**PAD-3**  
**PADMARK BUSINESS PARK-Lot 3**  
 1190 MEADOWBROOK PKWY  
 COLORADO SPRINGS, CO 80915  
 EL PASO COUNTY, COLORADO

**Subject:** Cloud+  
**Page Label:** [1] Padmark Lot 3 - Electrical - 061818-ES-1  
**Author:** dskendall  
**Date:** 8/8/2018 12:12:09 PM  
**Color:** ■

- 1 PHOTOMETRIC SITE PLAN
8 SCALE: 1/16" = 1'-0"

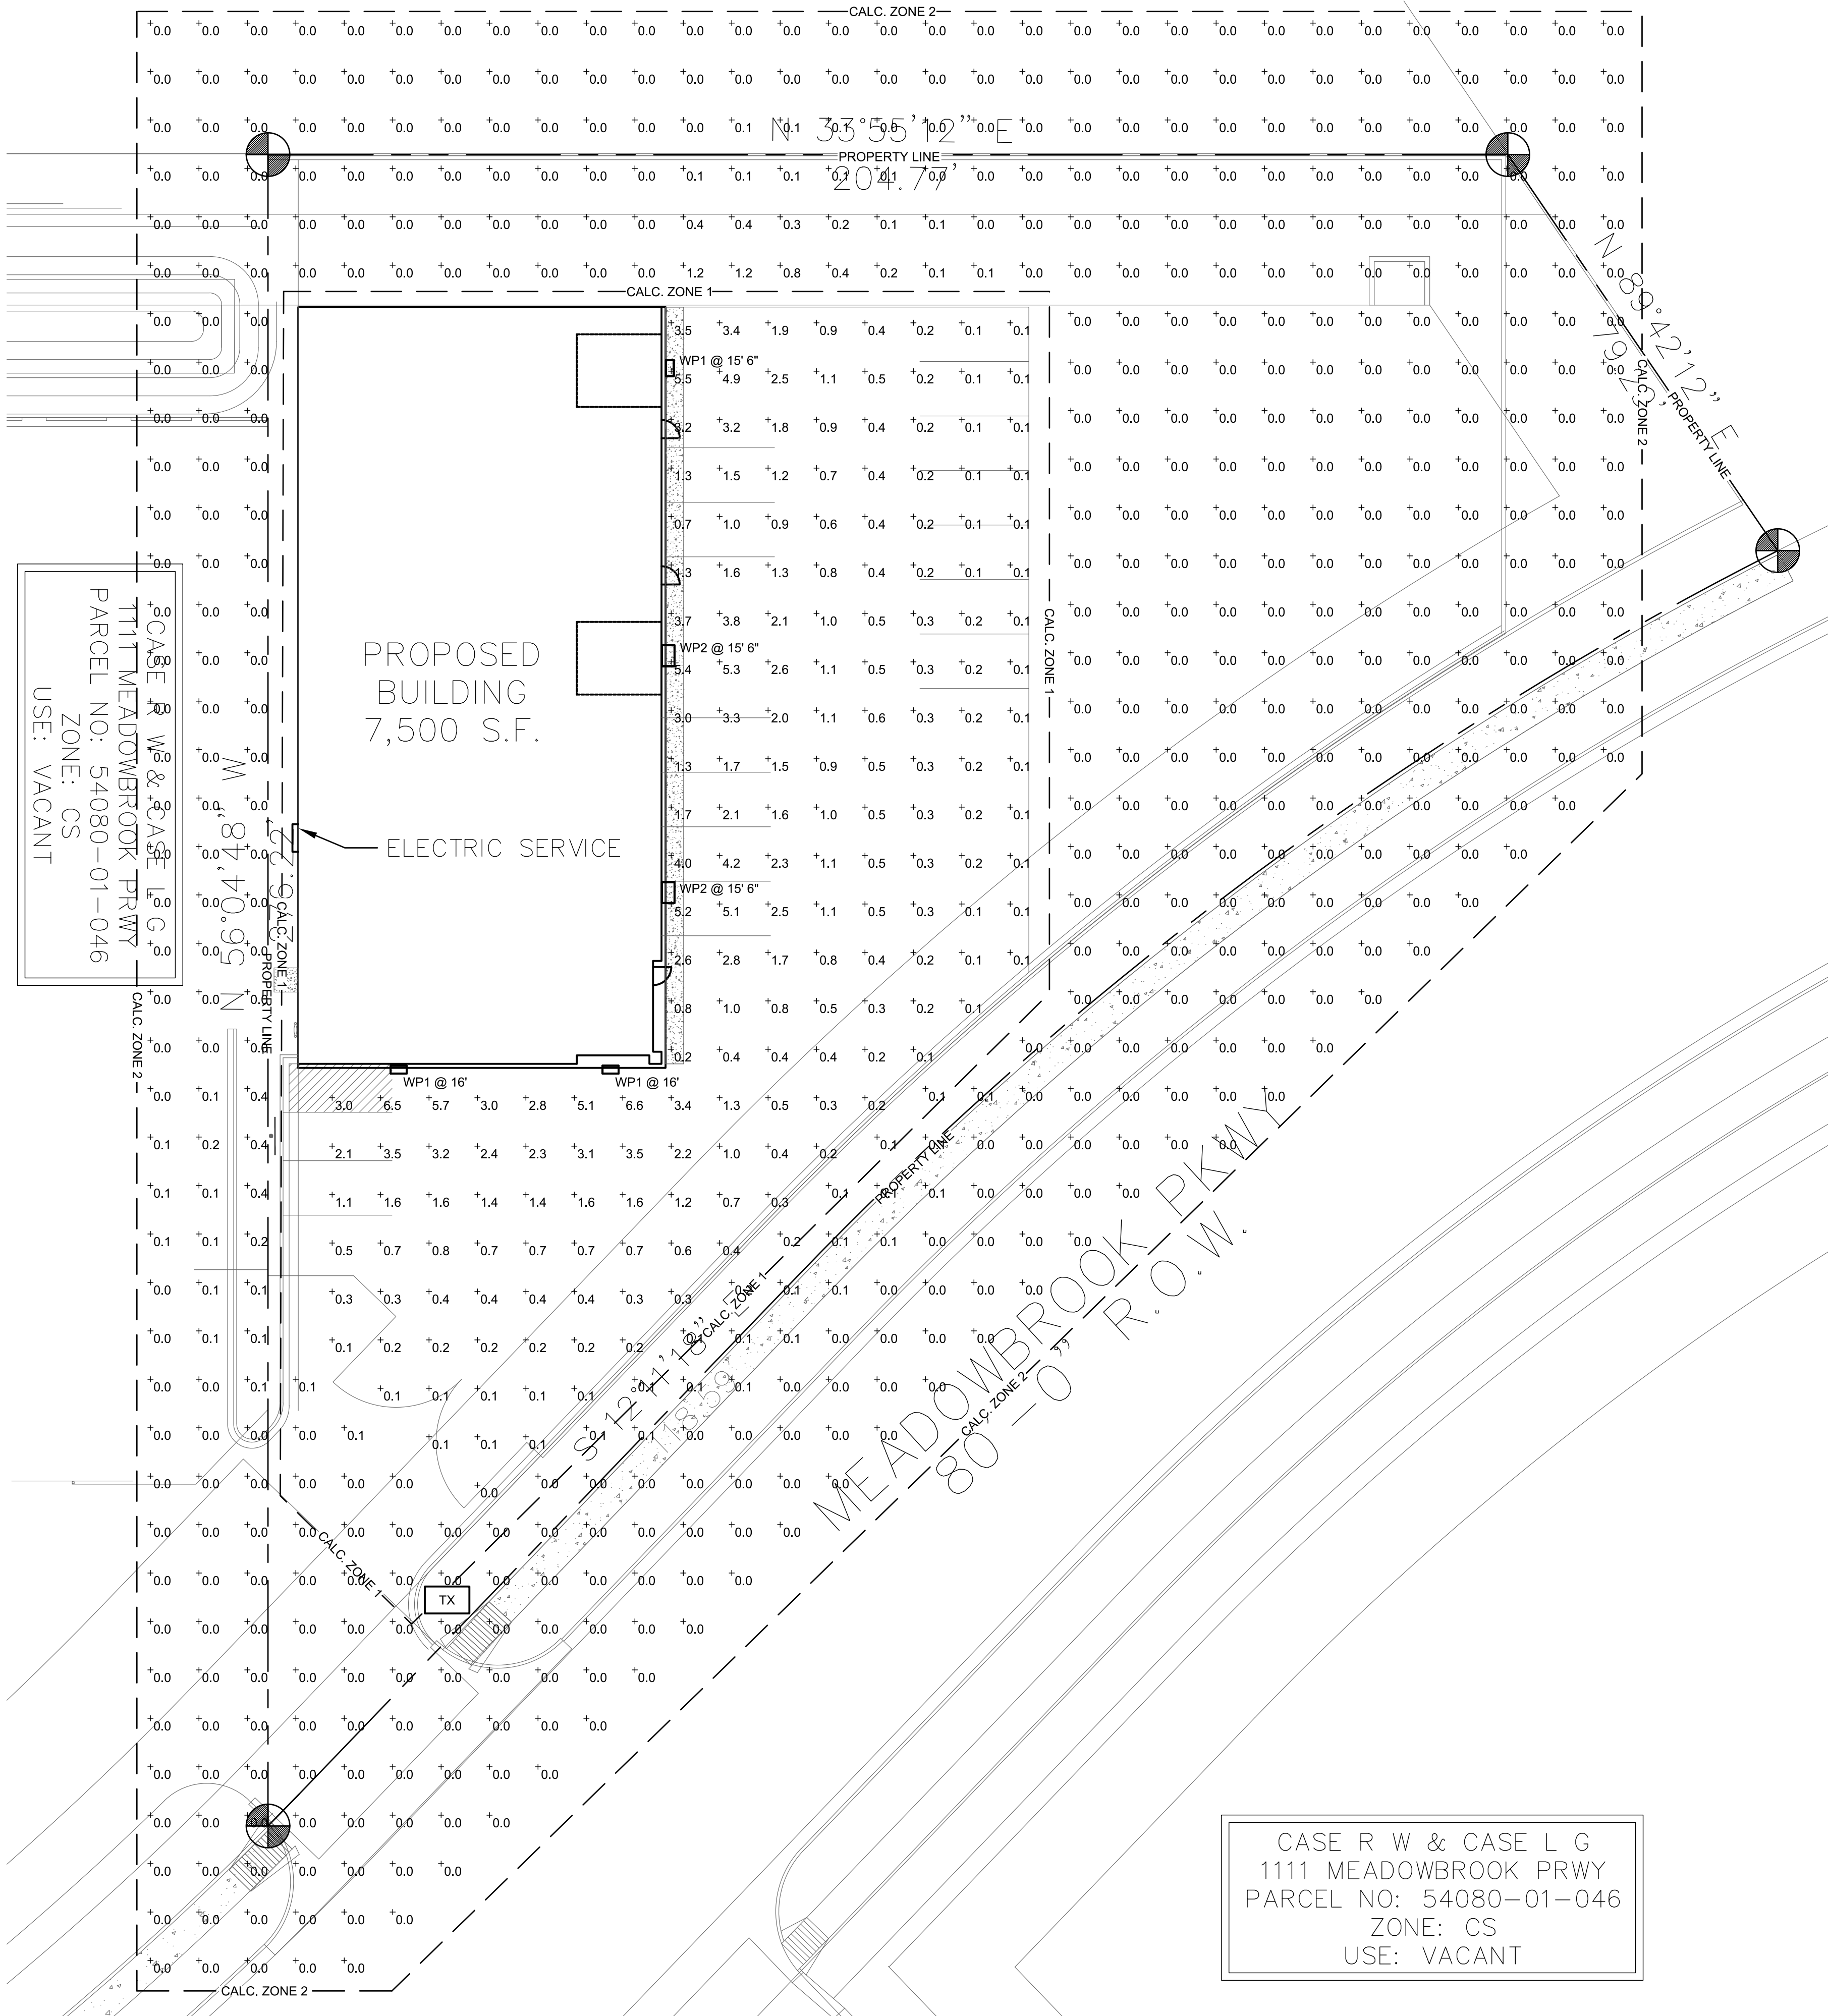
The maximum here is 0.1 due to the adjacent property being zoned residential.

Max levels are 0.1 due to being adjacent to a public right of way

20 foot maximum in parking area.
